From: Laura Gibbons <Laura.Gibbons@arun.gov.uk>
Sent: 01 June 2021 15:36
To: Planning.Responses <Planning.Responses@arun.gov.uk>
Cc: Michael Eastham <Michael.Eastham@arun.gov.uk>
Subject: RE: Planning Consultation on: A/85/21/DOC

Thank you for consulting us on this discharge of conditions application, we have the following comments.

Application No: A/85/21/DOC
Registered: 30th April 2021
Site Address: Land at Dappers Lane Angmering Littlehampton
Description of Works: Approval of details reserved by condition imposed under ref A/76/20/PL relating to Condition Nos 17 - existing & proposed ground levels, proposed finished floor levels, levels of any paths, drives, garages & parking areas & the proposed completed height of development & any retaining walls, 18 - surface water drainage, 19 - maintenance & management of surface water drainage, 21 - discharge flows to watercourses and 22 foul drainage system.

Title **Volumetrics Assessment**

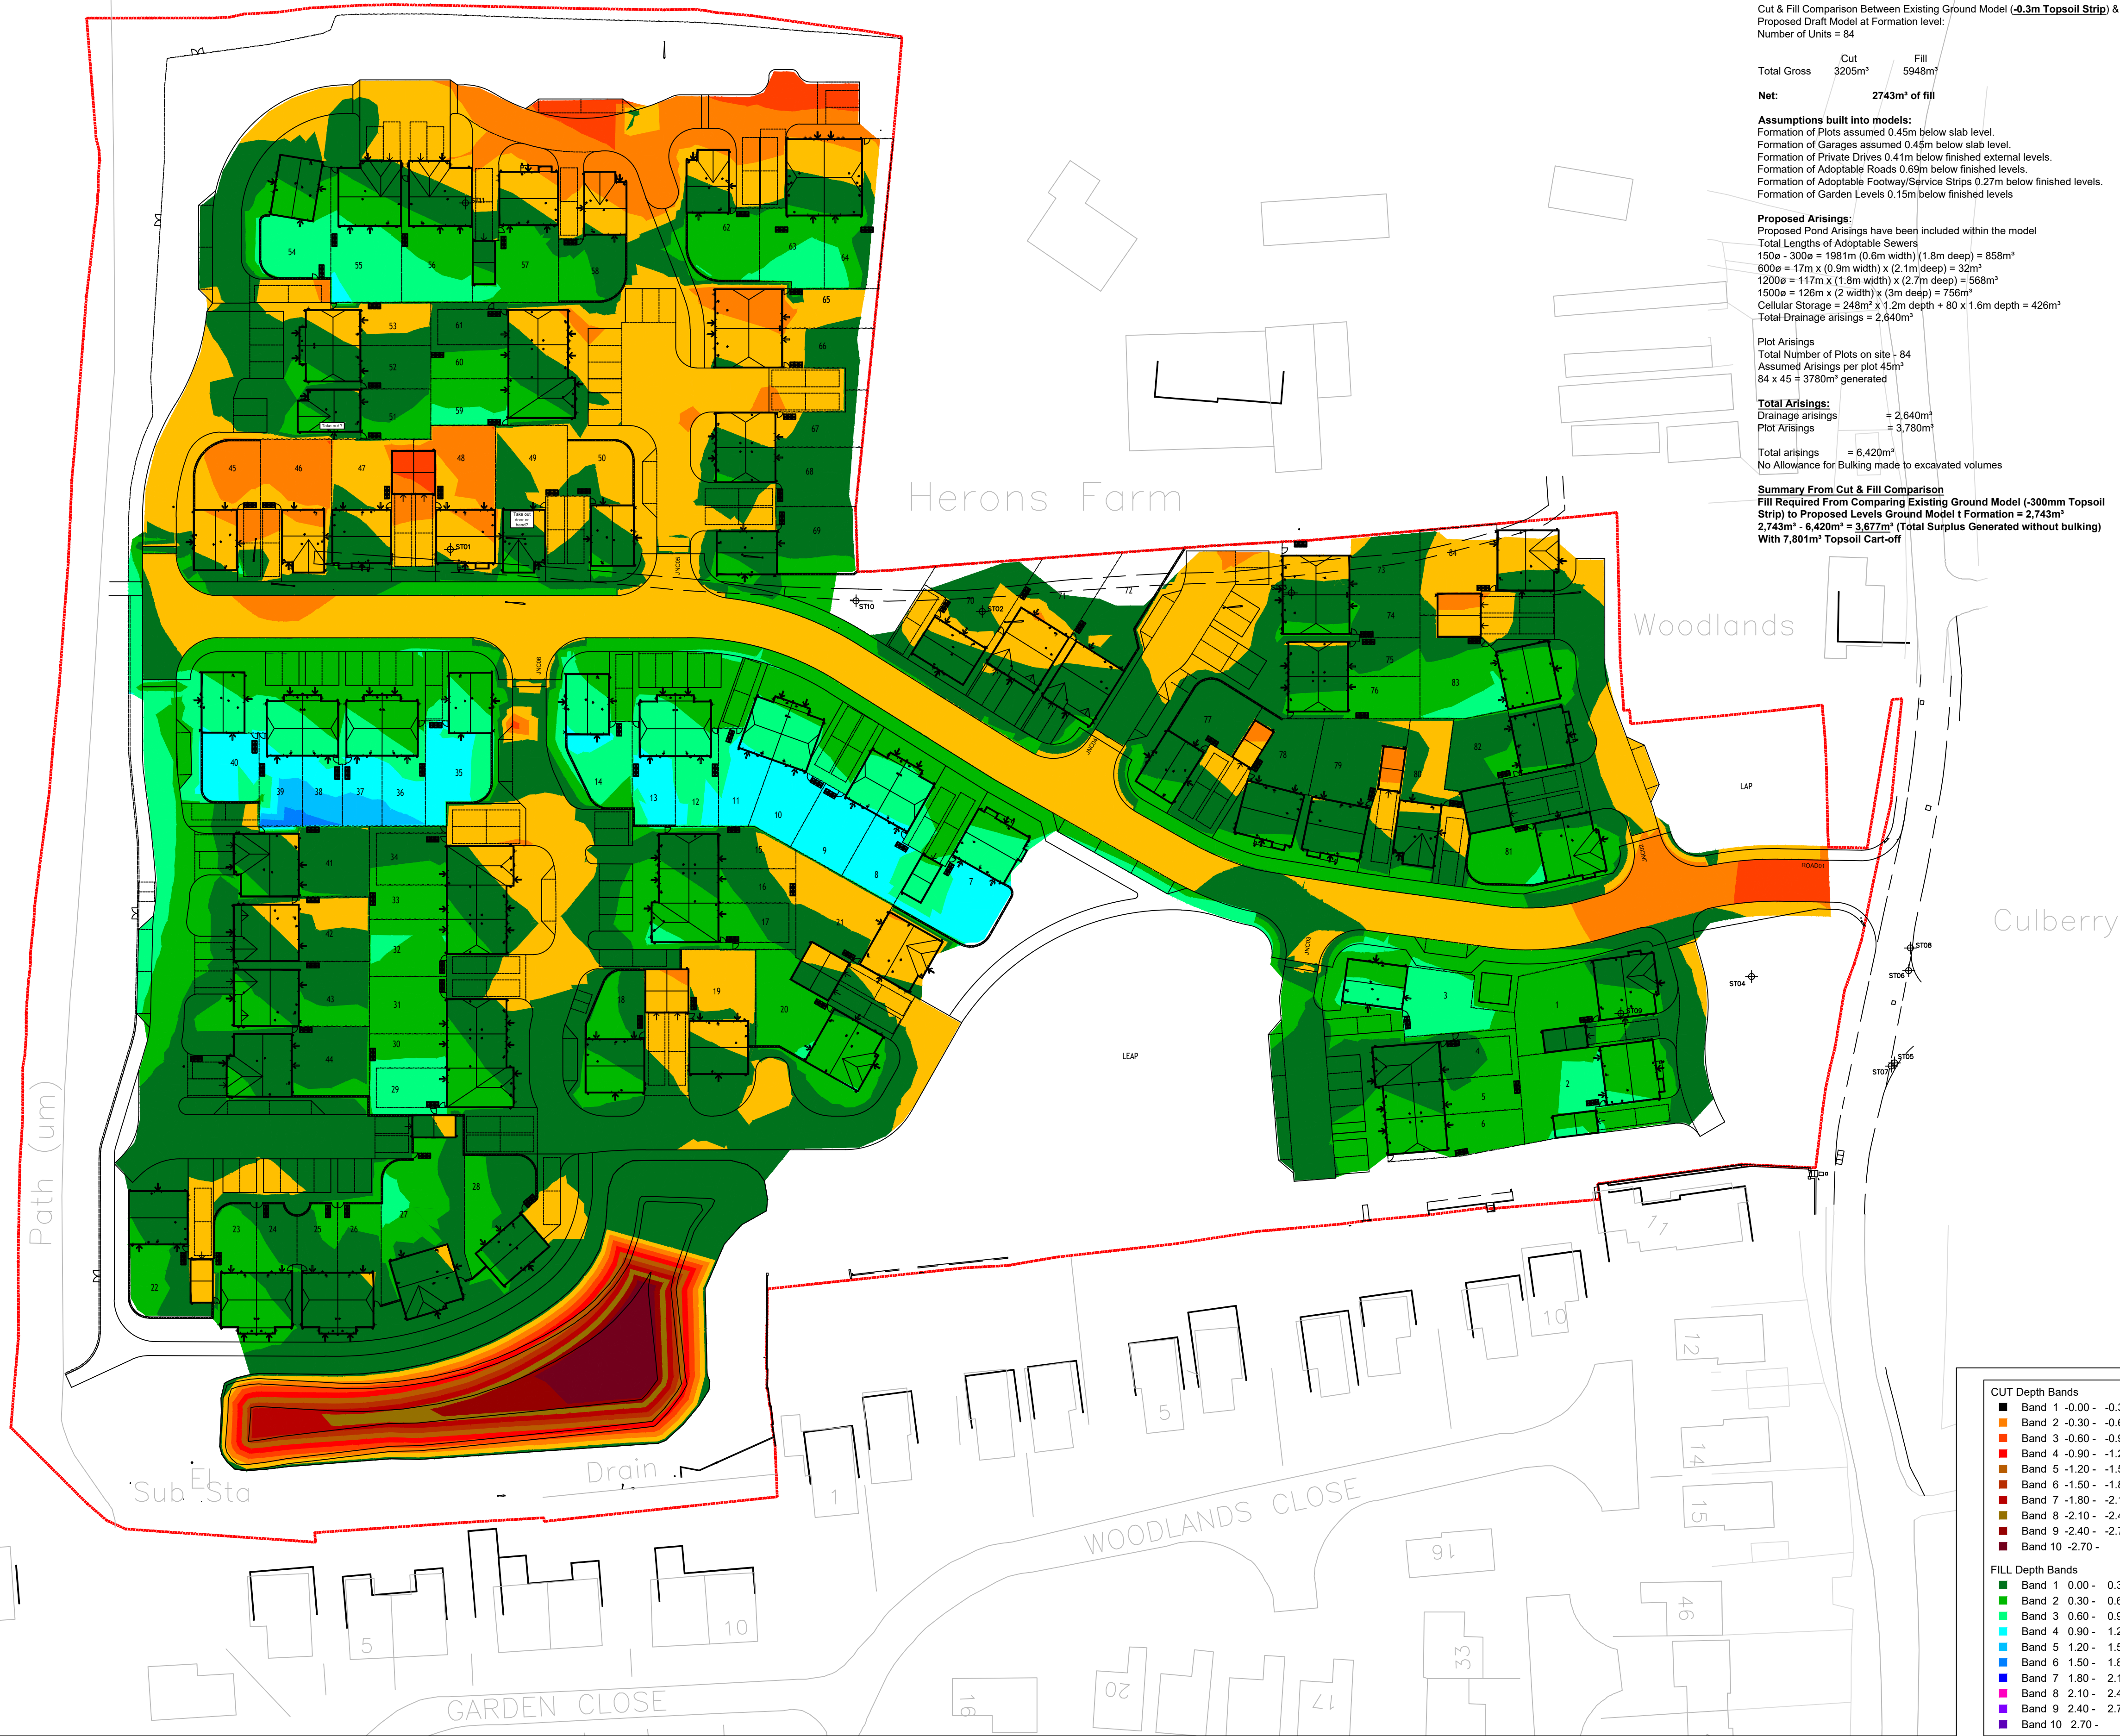
We note that significant land raising of circa 1m is proposed. We do not support this and will need to carefully consider the impacts of any such proposals on adjacent sites in terms of surface water runoff and groundwater levels.
